From: Amanda Scholes on behalf of Planning.Responses
Sent: 09 January 2020 12:12
To: Planning Scanning
Subject: FW: CEMP - LU/339/19/DOC & LU/340/19/DOC
Attachments: Littlehampton CEMP Rev E Text.docx; STVAL2819121719040.pdf; 01410 - (Lym.) High level Draft Programme.pdf

Dear Michael,
I include my comments re Version E of the Construction Environmental Management Plan in this case.

SITE DELIVERY POINTS.

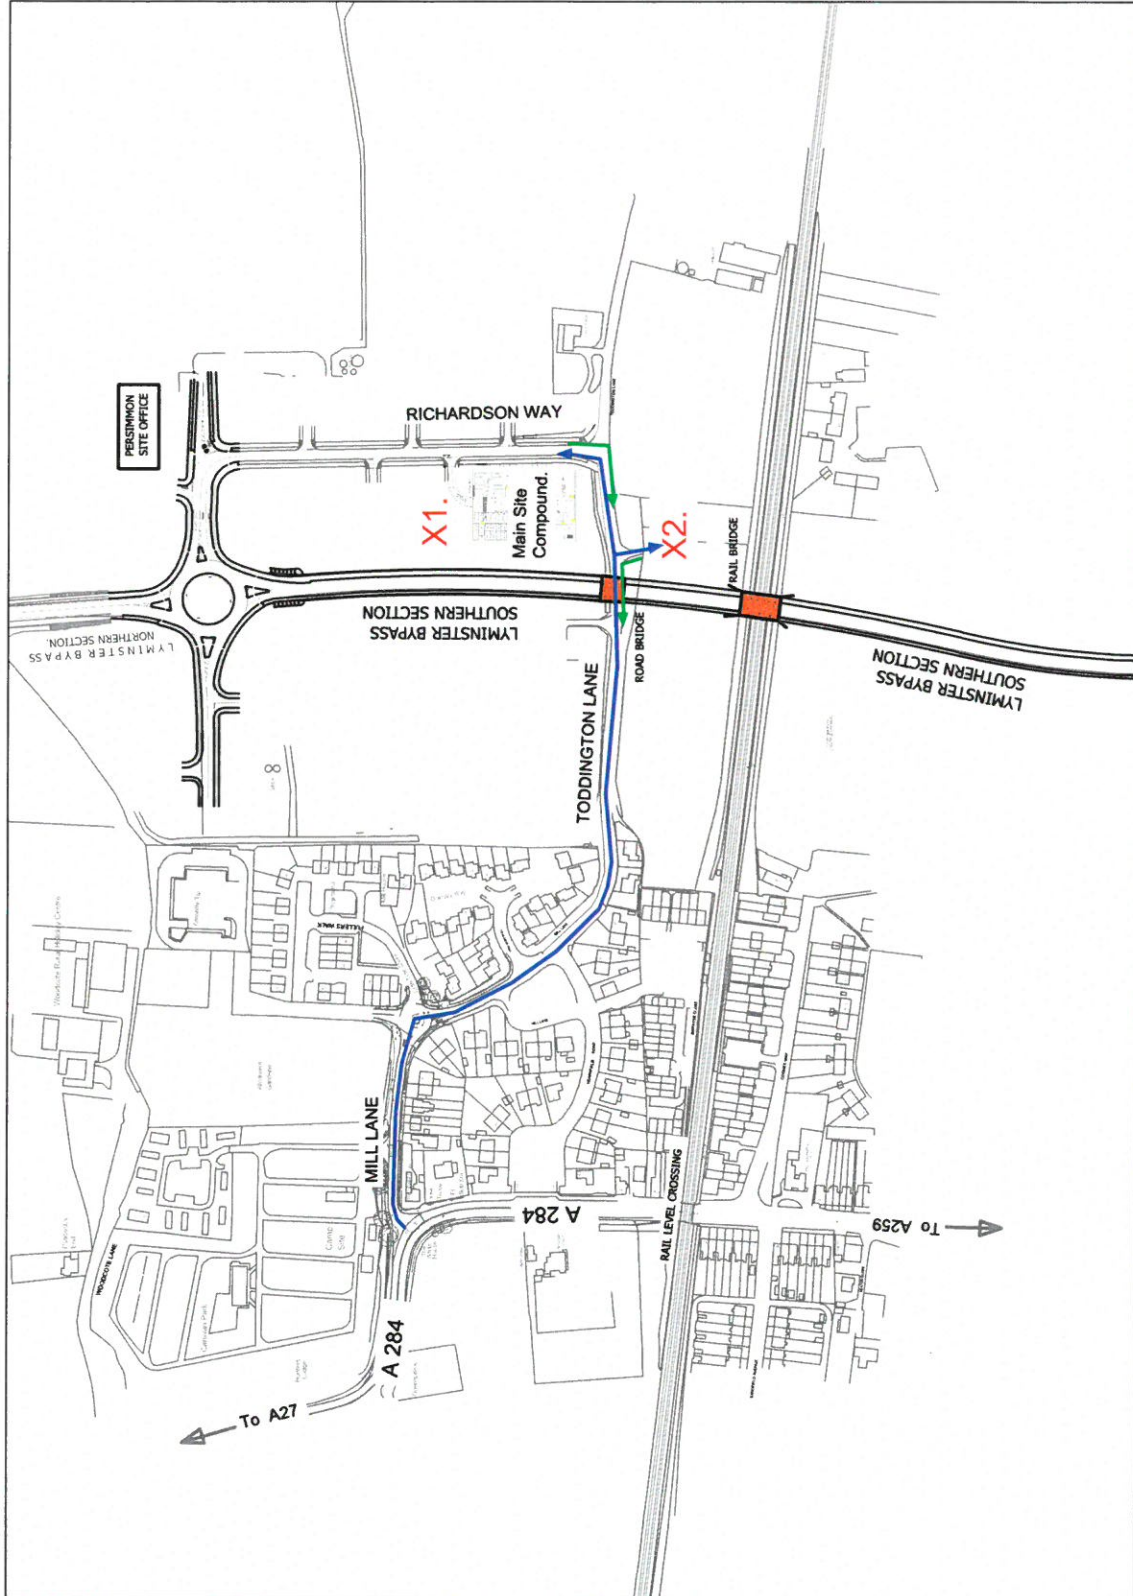
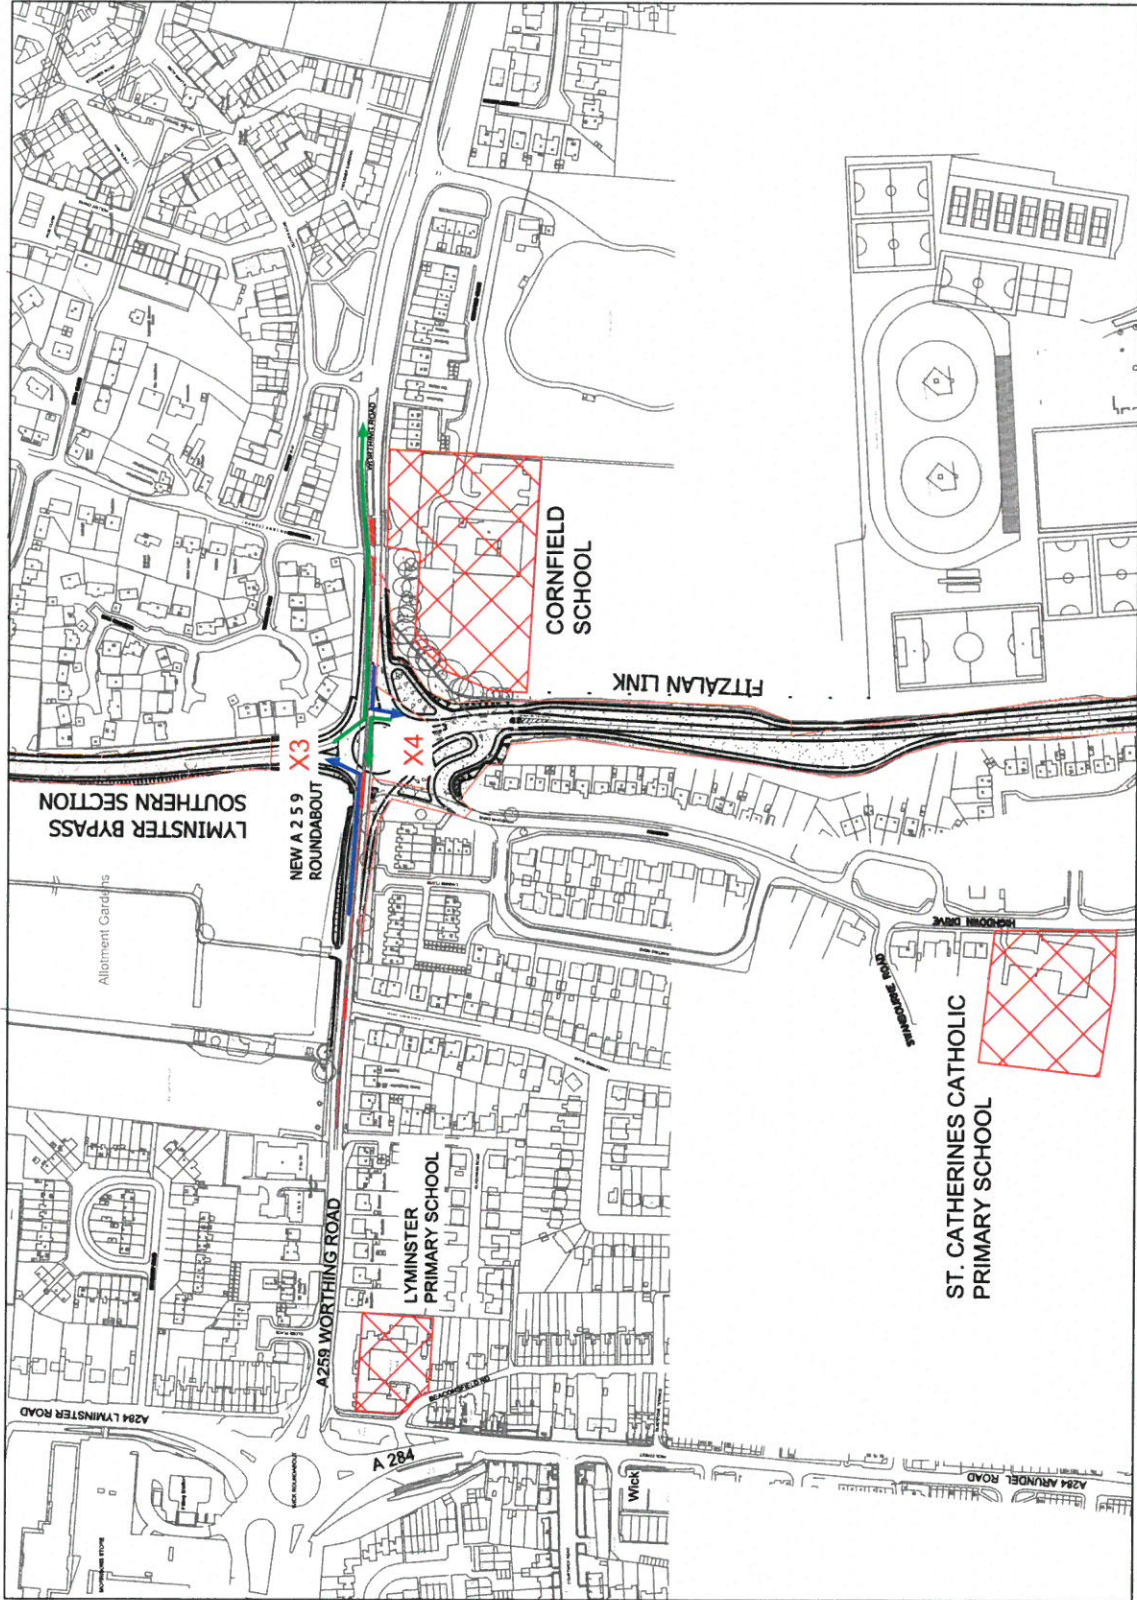
These locations as indicated on Appendix 5 as X2 – X5 require proper definition ie a site layout showing the entrance/exit to these facilities and the location of site storage, car parking, etc within, in relation to exiting sensitive receptors

Delivery Point 2: Please note that I have already made comment in respect of the building compound for proposed residential units here which should be removed as far as possible away from existing residential units to the east to prevent noise and dust detriment.

Delivery Point 2 , 3, 4 and 5 : As above, any building compound or delivery point should be removed as far as possible away from existing sensitive receptors to prevent noise and dust detriment.
